CITY OF ALBUQUERQUE

PLANNING DEPARTMENT – Development Review Services

April 22, 2016

RE: American Toyota (File: C18D012)
Grading and Drainage Plan, Engineer's Stamp Date 7-22-15
Engineer's Certification Dated 4-20-16

DAVID SOULE P.E. #14522	AMERICAN TOYOTA		DRAWN BY WCWJ
	GRADING AND DRAINAGE PLAN		DATE 7-22-15
	 Rio Grande Engineering 1806 CENTRAL AVENUE SE SUITE 201 ALBUQUERQUE, NM 87106 (505) 872-0999		21403-LAYOUT-1-25-14
			SHEET # — JOB # 21403

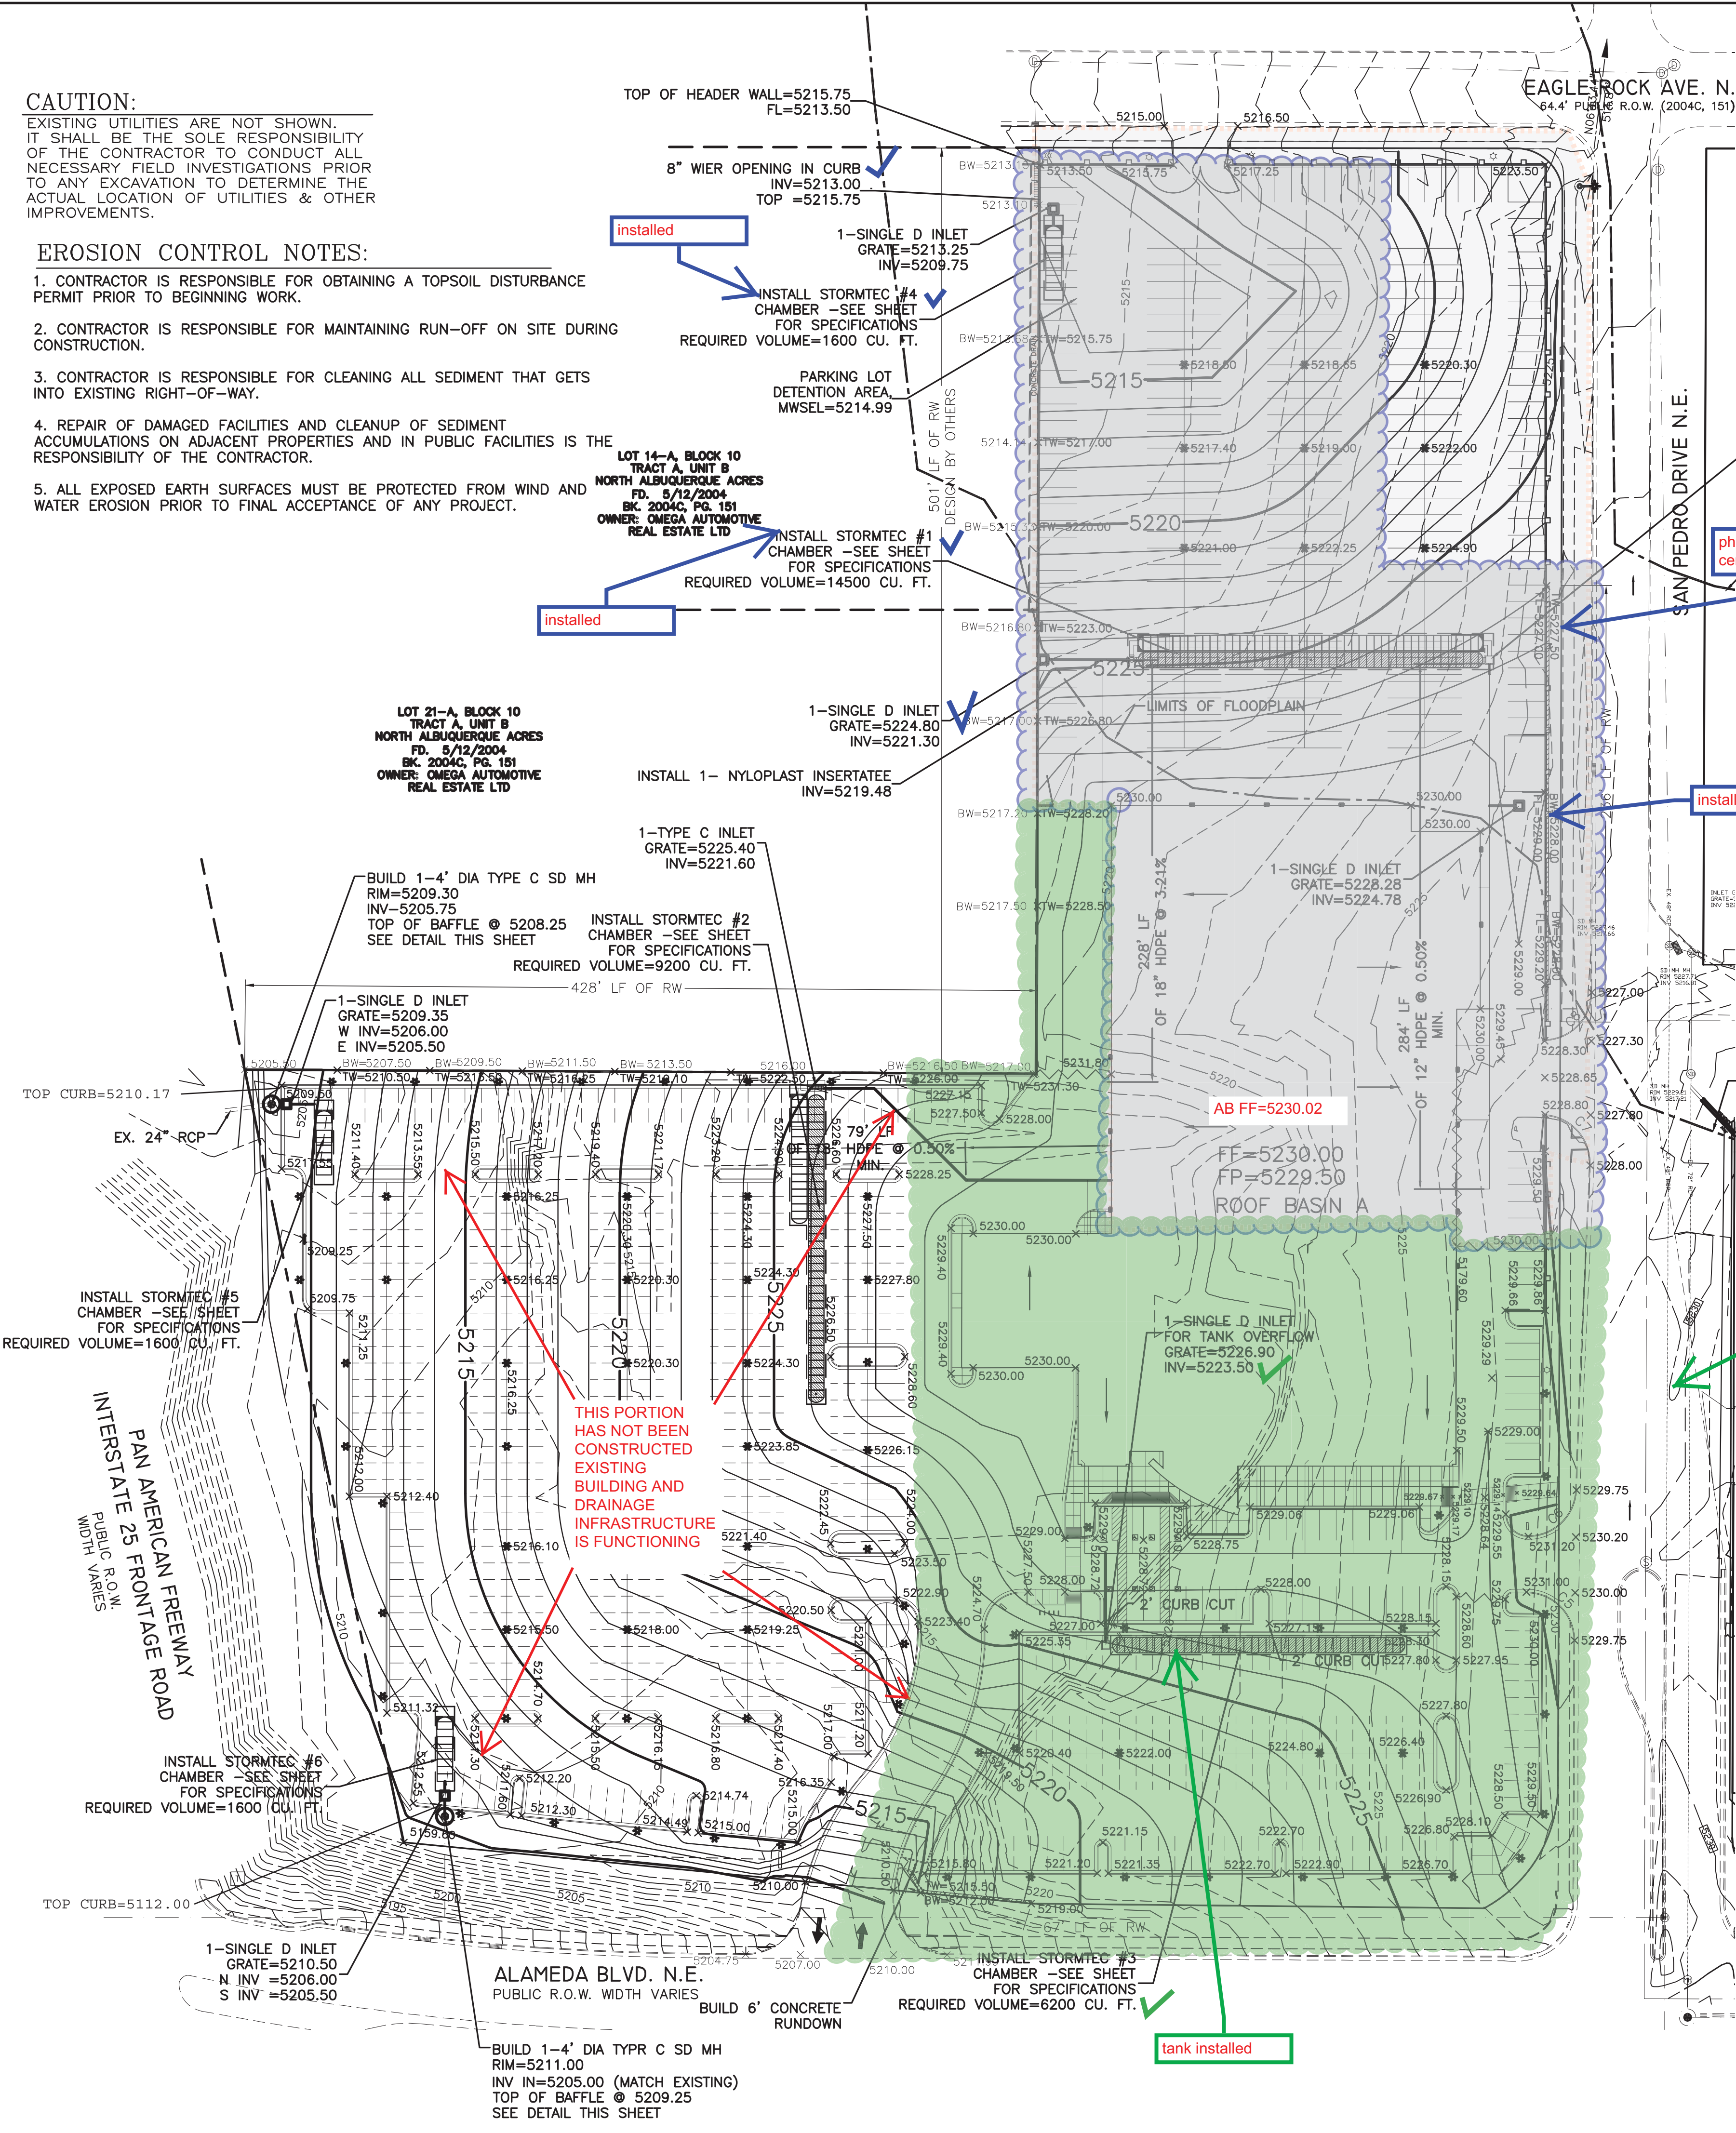
- Existing inlets at NE corner, behind wall, need to be cleared of all debris and trash
- After 90-days, the NE corner should be graded and paved, and a subsequent TEMPORARY C.O. must be sought. This subsequent TEMPORARY C.O. should be given indefinitely, until the remainder of the site is complete.
- Once the entire site is complete, a Permanent C.O. should be sought. Until then, only Temporary C.O.'s will be issued.
- The Engineer's Certificate should include the addition of inlets and StormTec chambers that were added in the NW corner.
- If this project is to be phased, and it is intended to obtain Permanent C.O. after each phase, then intermediate grading plans are required.
